**KIRKLEES METROPOLITAN COUNCIL
TOWN AND COUNTRY PLANNING ACT 1990
HIGHWAYS DEVELOPMENT CONTROL KP20H**

PLANNING REF 2014/61/91677/E0/BT
CATEGORY Small Major

PROPOSAL RESERVED MATTERS APPLICATION
FOR ERECTION OF 34 DWELLINGS

LOCATION FORMER VALLEY WORKS
OFF UNION STREET
HECKMONDWIKE
WF16 0HH

Drawing Title  
**Site Layout and Streetscene**

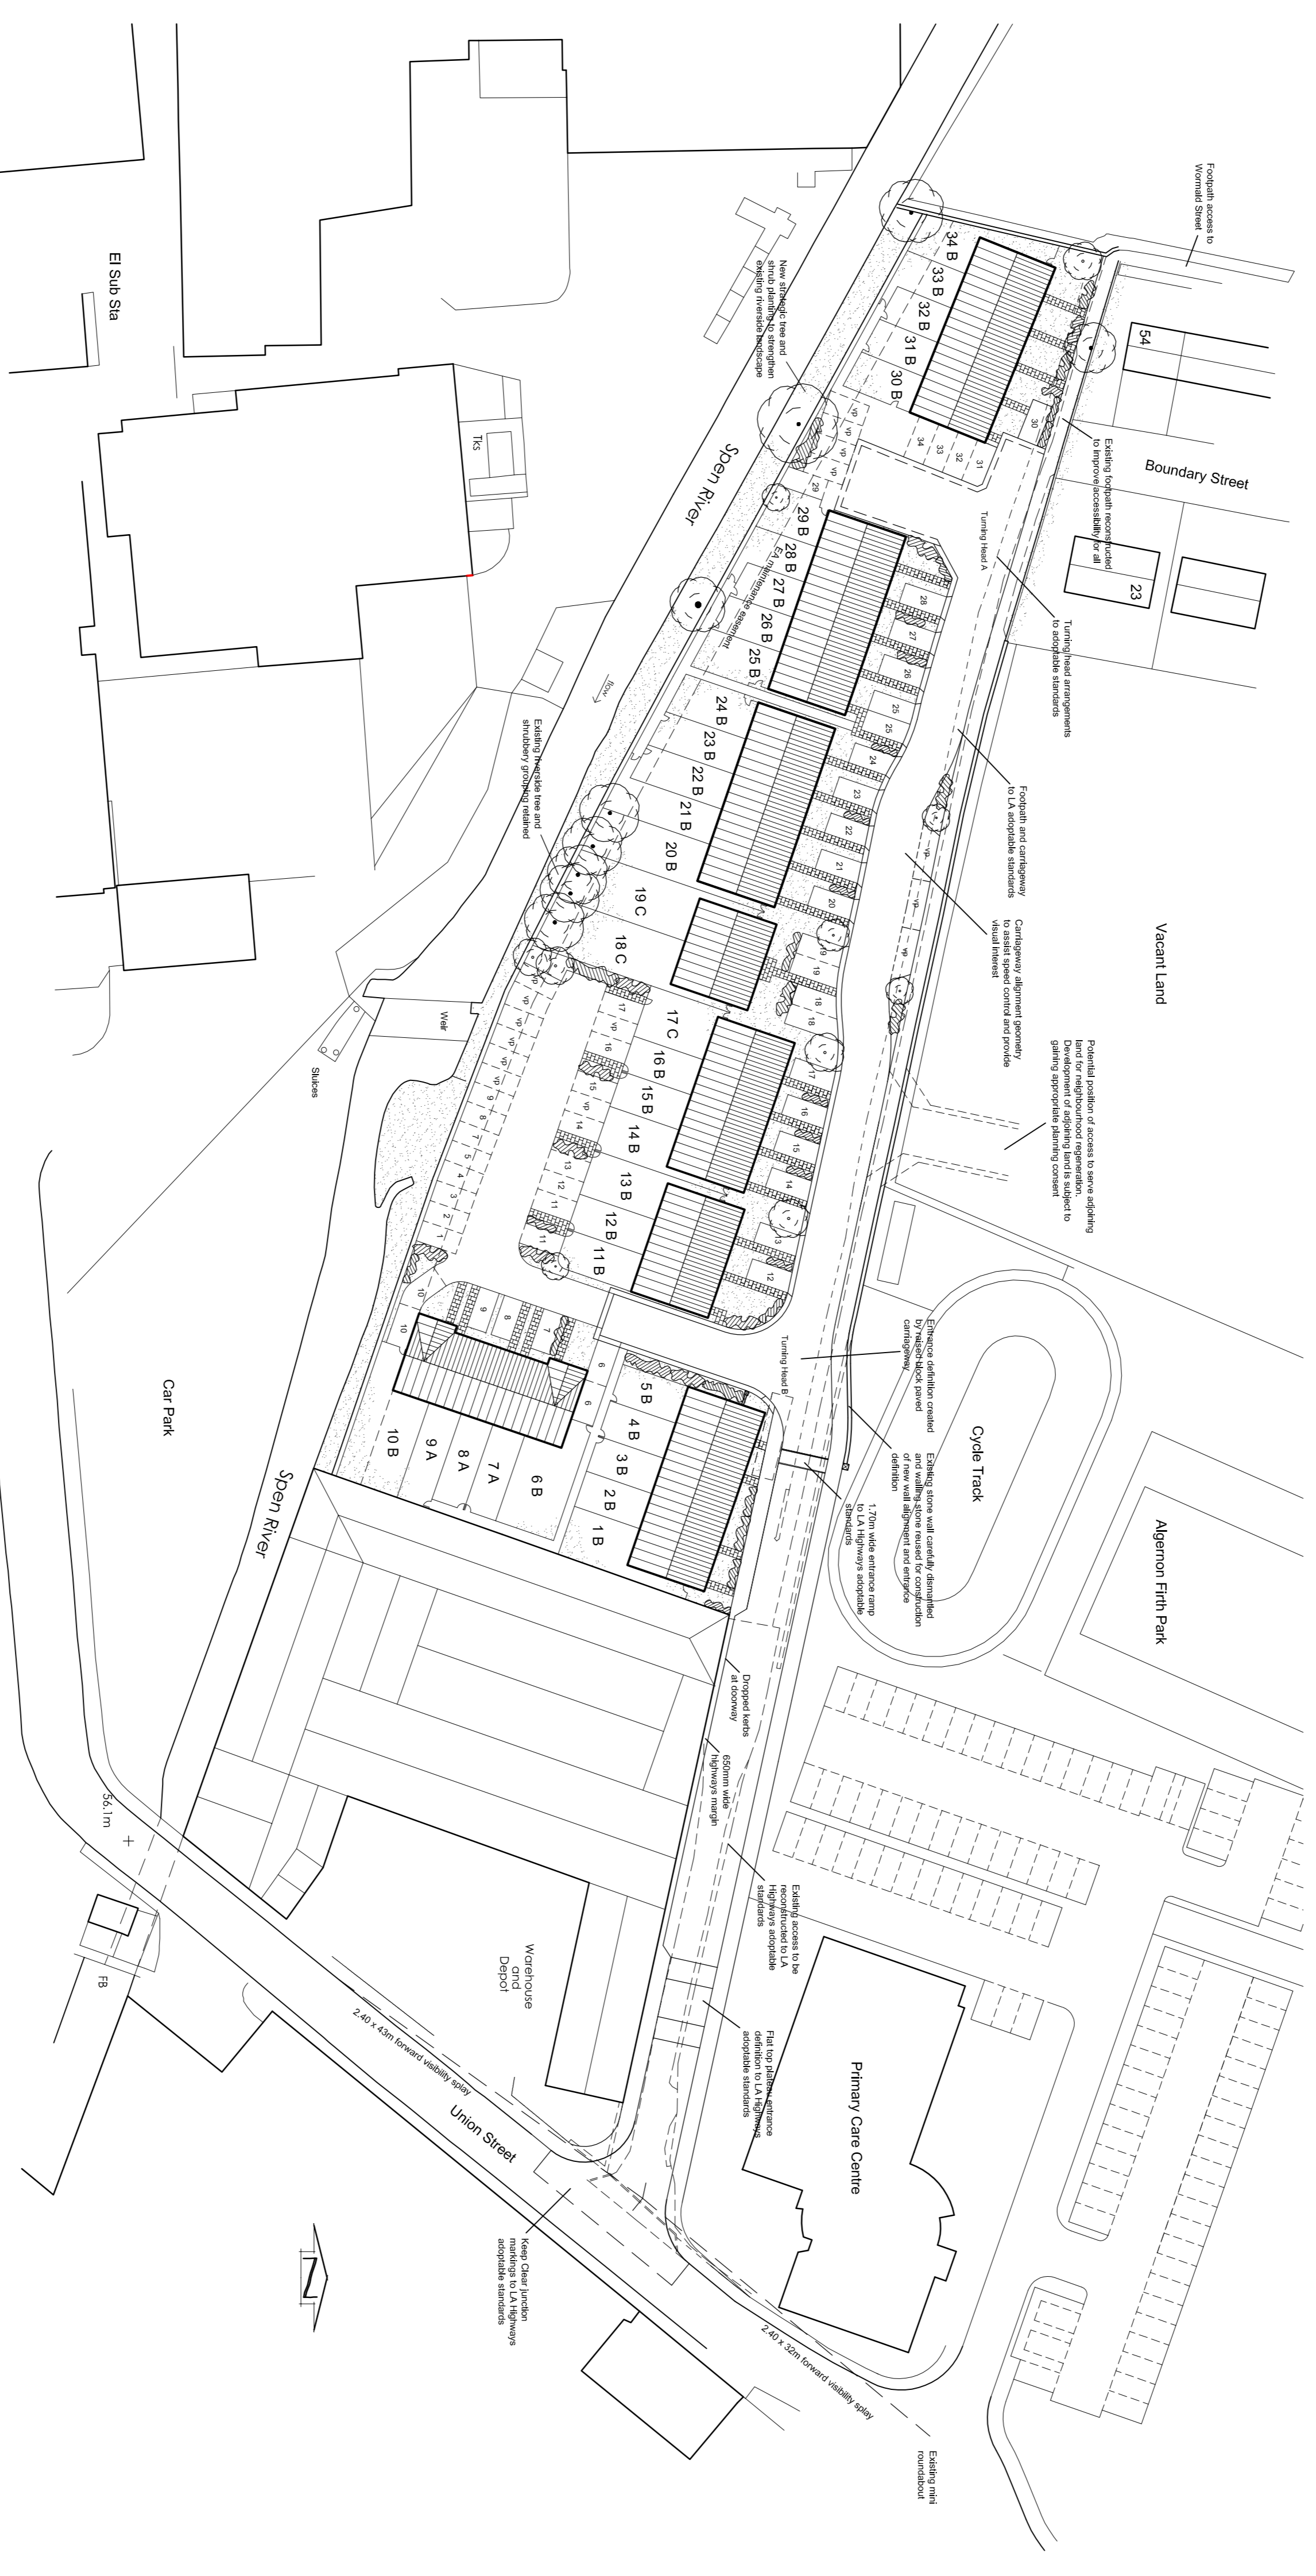
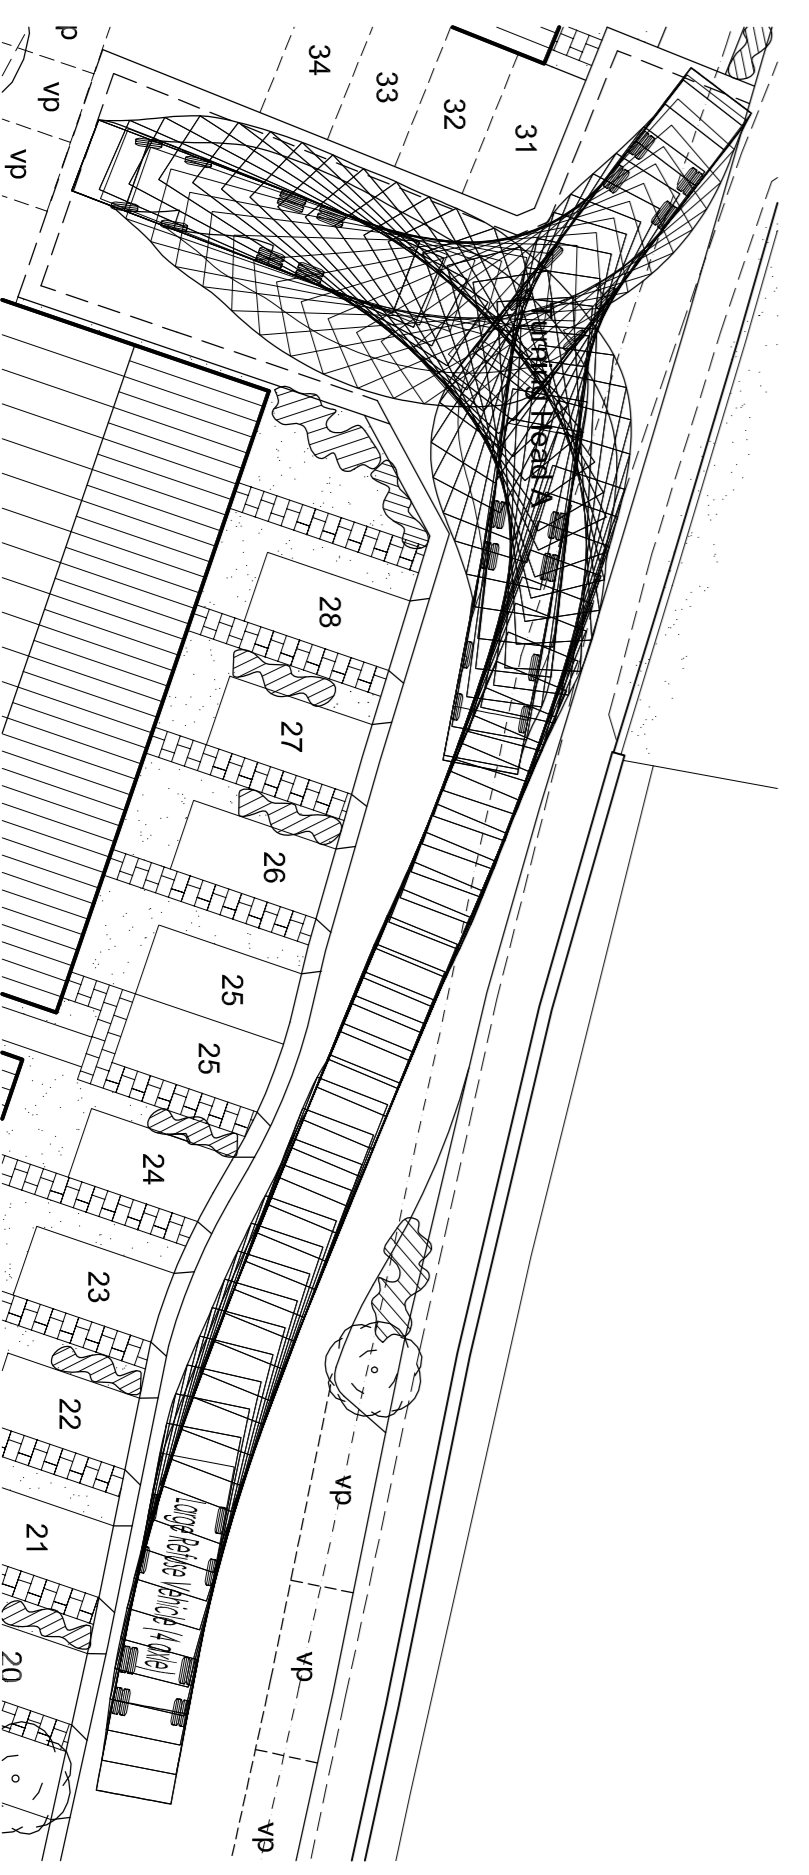
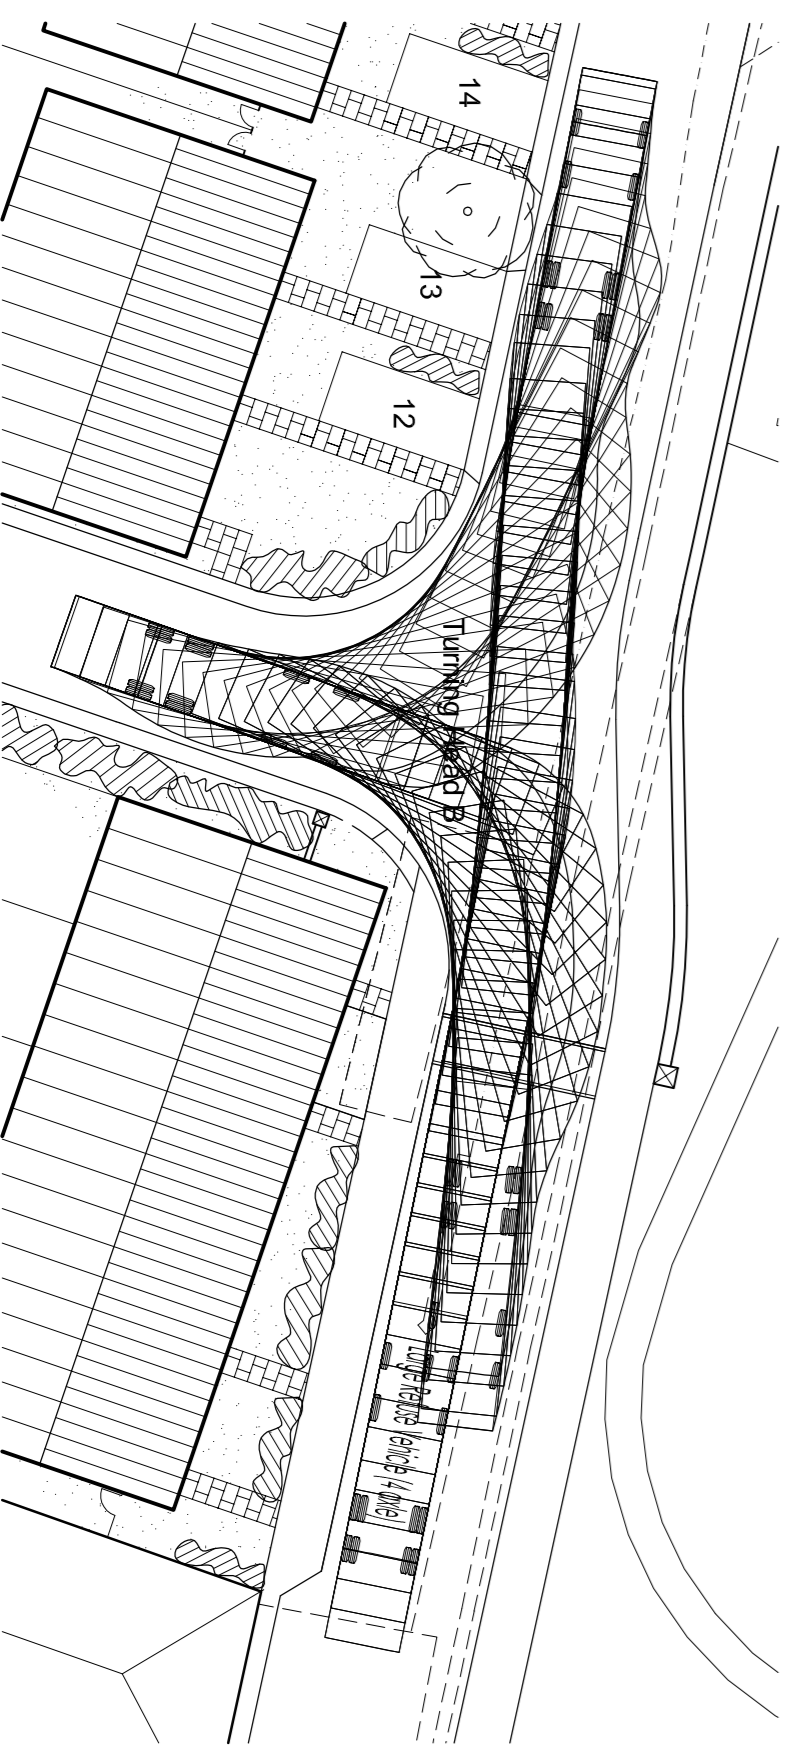
Highways Development Management has received and reviewed the amended site plan drawing no. 412/01 Rev H.

To sum: off-street parking provision and layout are considered acceptable.

1) Prior to development commencing a detailed scheme for the proposed internal adoptable estate road including improvements to public footpath SPE/106/50 (with reference to drawing no. 412/01 Rev H) shall be submitted to and approved in writing by the Local Planning Authority. The scheme shall include full sections with suitable gradients and vertical curves, traffic calming, drainage works, street lighting, lining, surface finishes, together with an independent Road Safety Audit covering all aspects of the work. Before any building is brought into use the scheme shall be completed in accordance with the approved details and retained thereafter.
